Subject: RE: Planning Consultation on A/62/20/DOC

APPLICATION NO: A/62/20/DOC

Site Address: Pound Place Roundstone Lane Angmering BN16 4AL

Description of Works: Approval of details reserved by condition imposed under ref APP/C3810/W/19/3220233 (A/51/18/PL) relating to Condition No 3 - surface water drainage.

DRAWING TITLE:
PROPOSED DRAINAGE LAYOUT
64 BED
SHEET 1

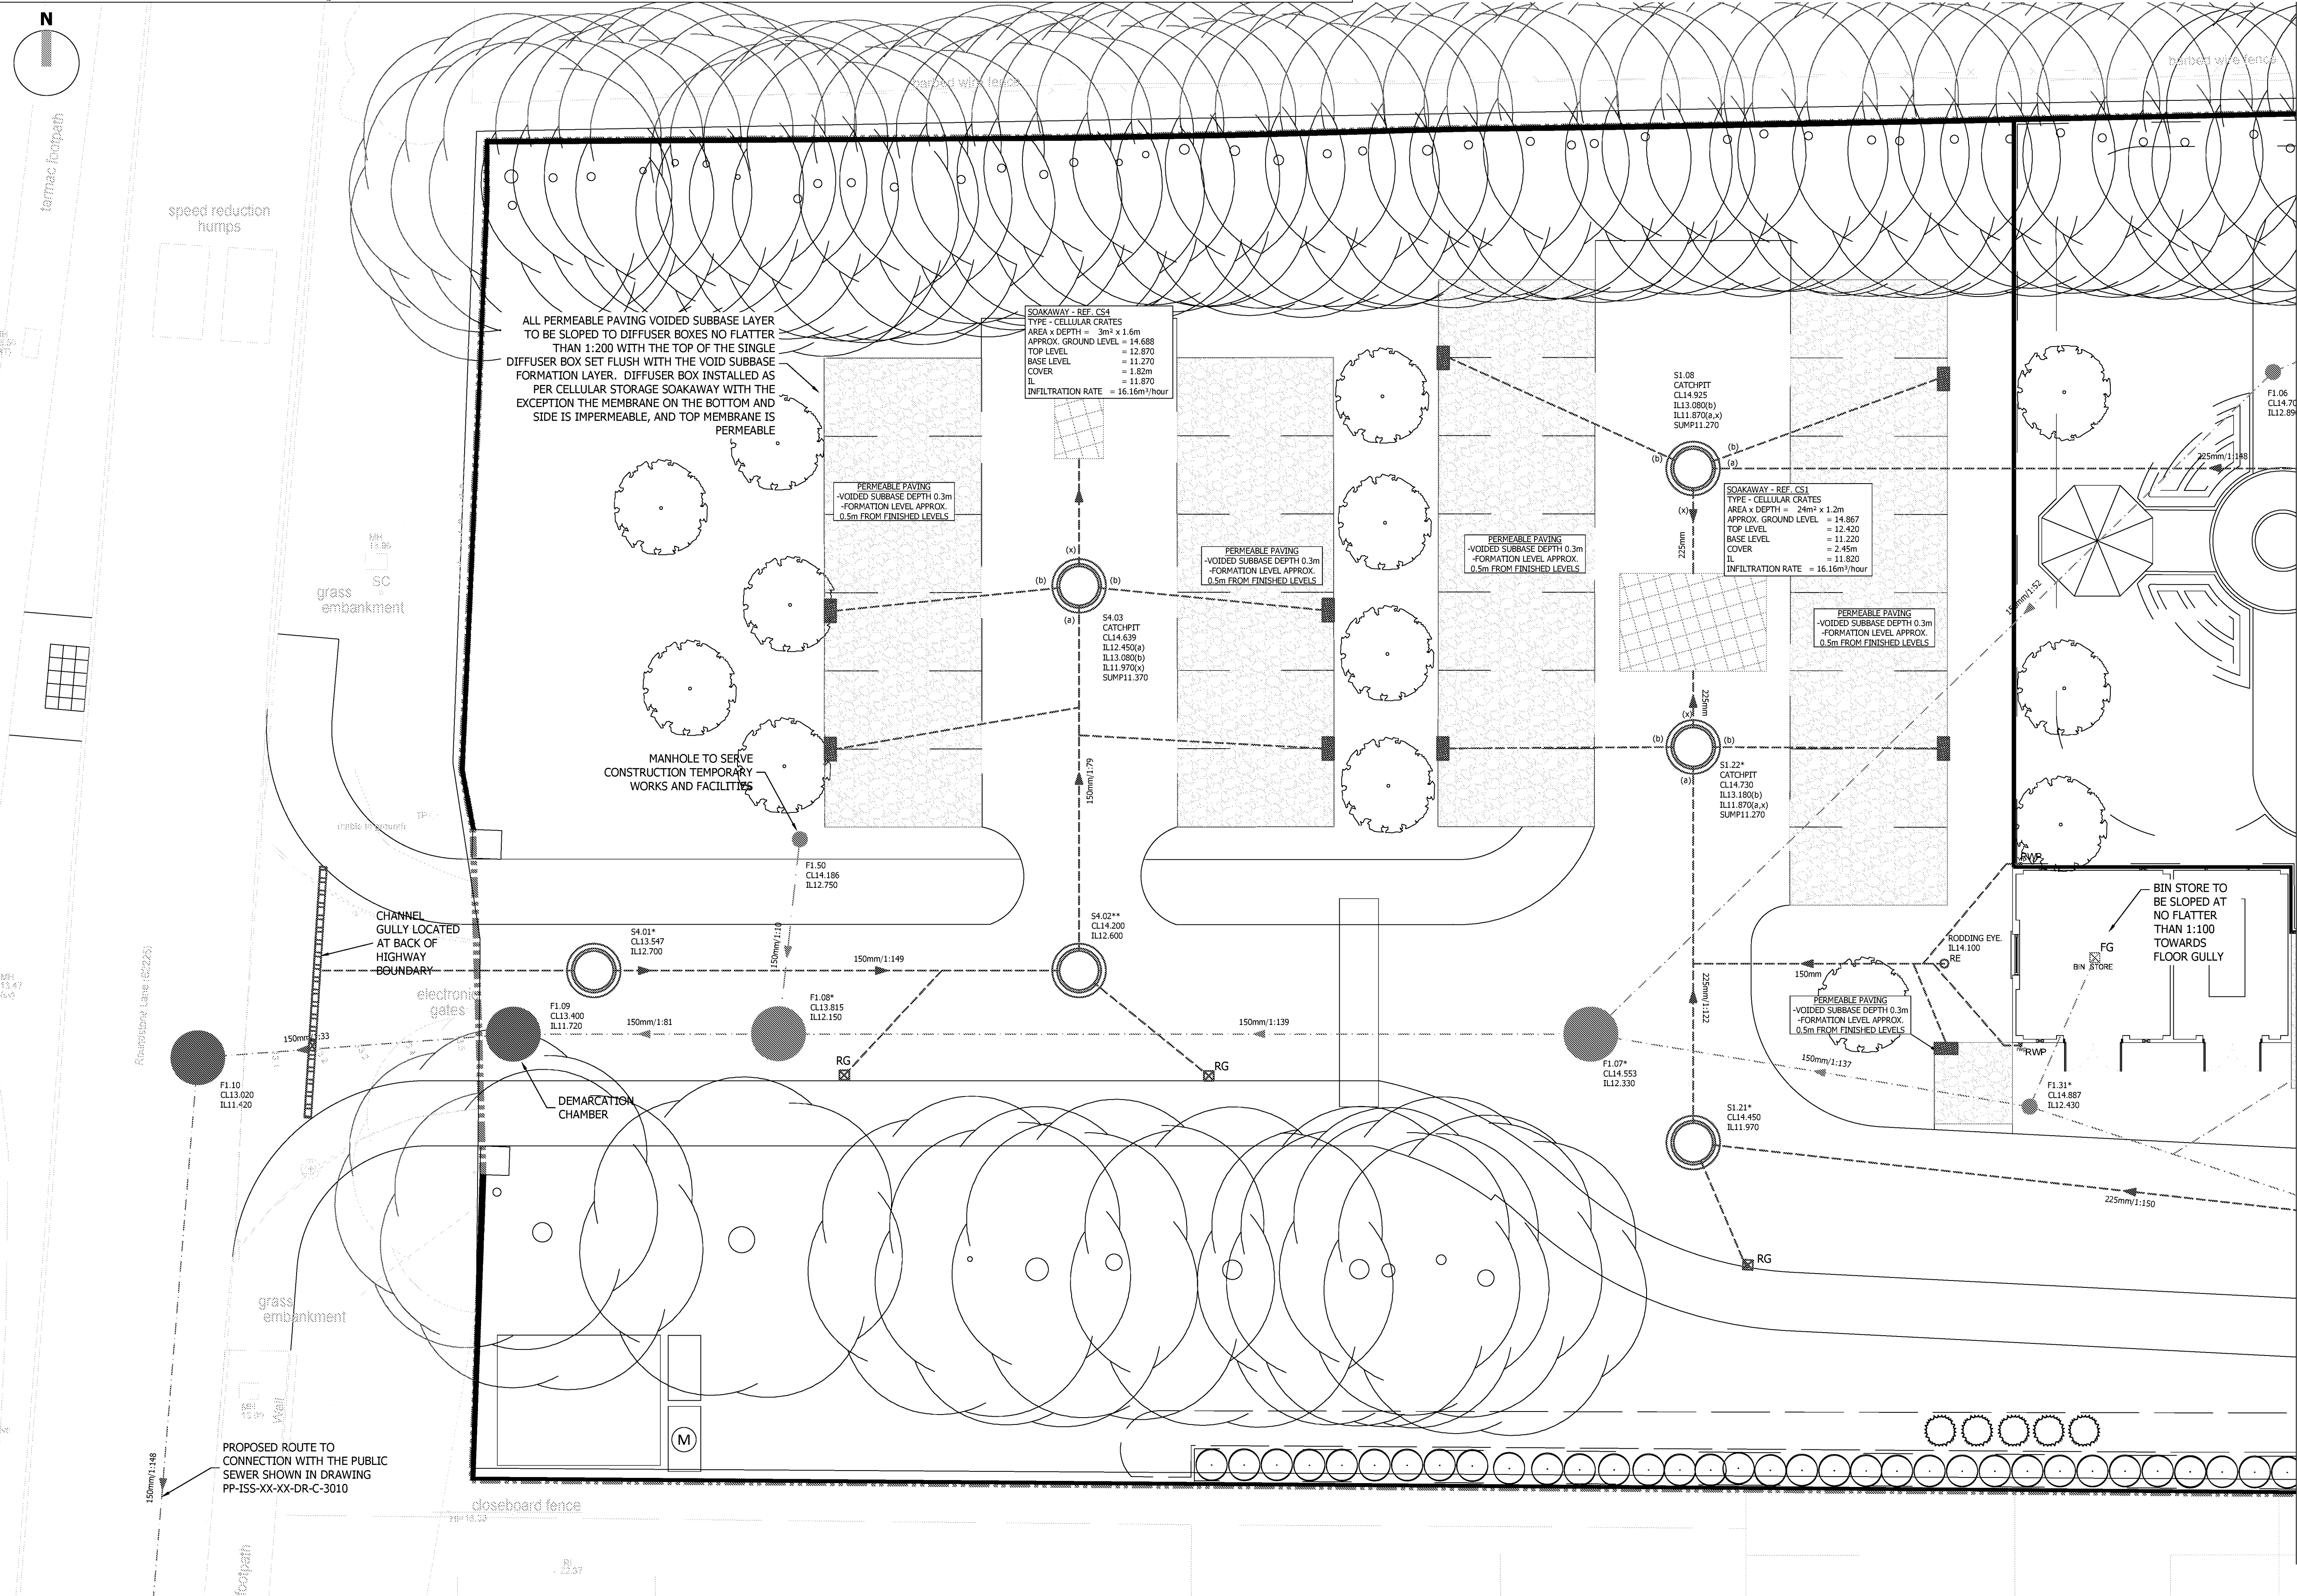
Please could the applicant highlight (on the drawings) as to what has changed in terms of the drainage design, since the approval of the original scheme associated with A/18/20/DOC and the referenced approved drawings. Please also supply all relevant drawings from the original approval that are still relevant.
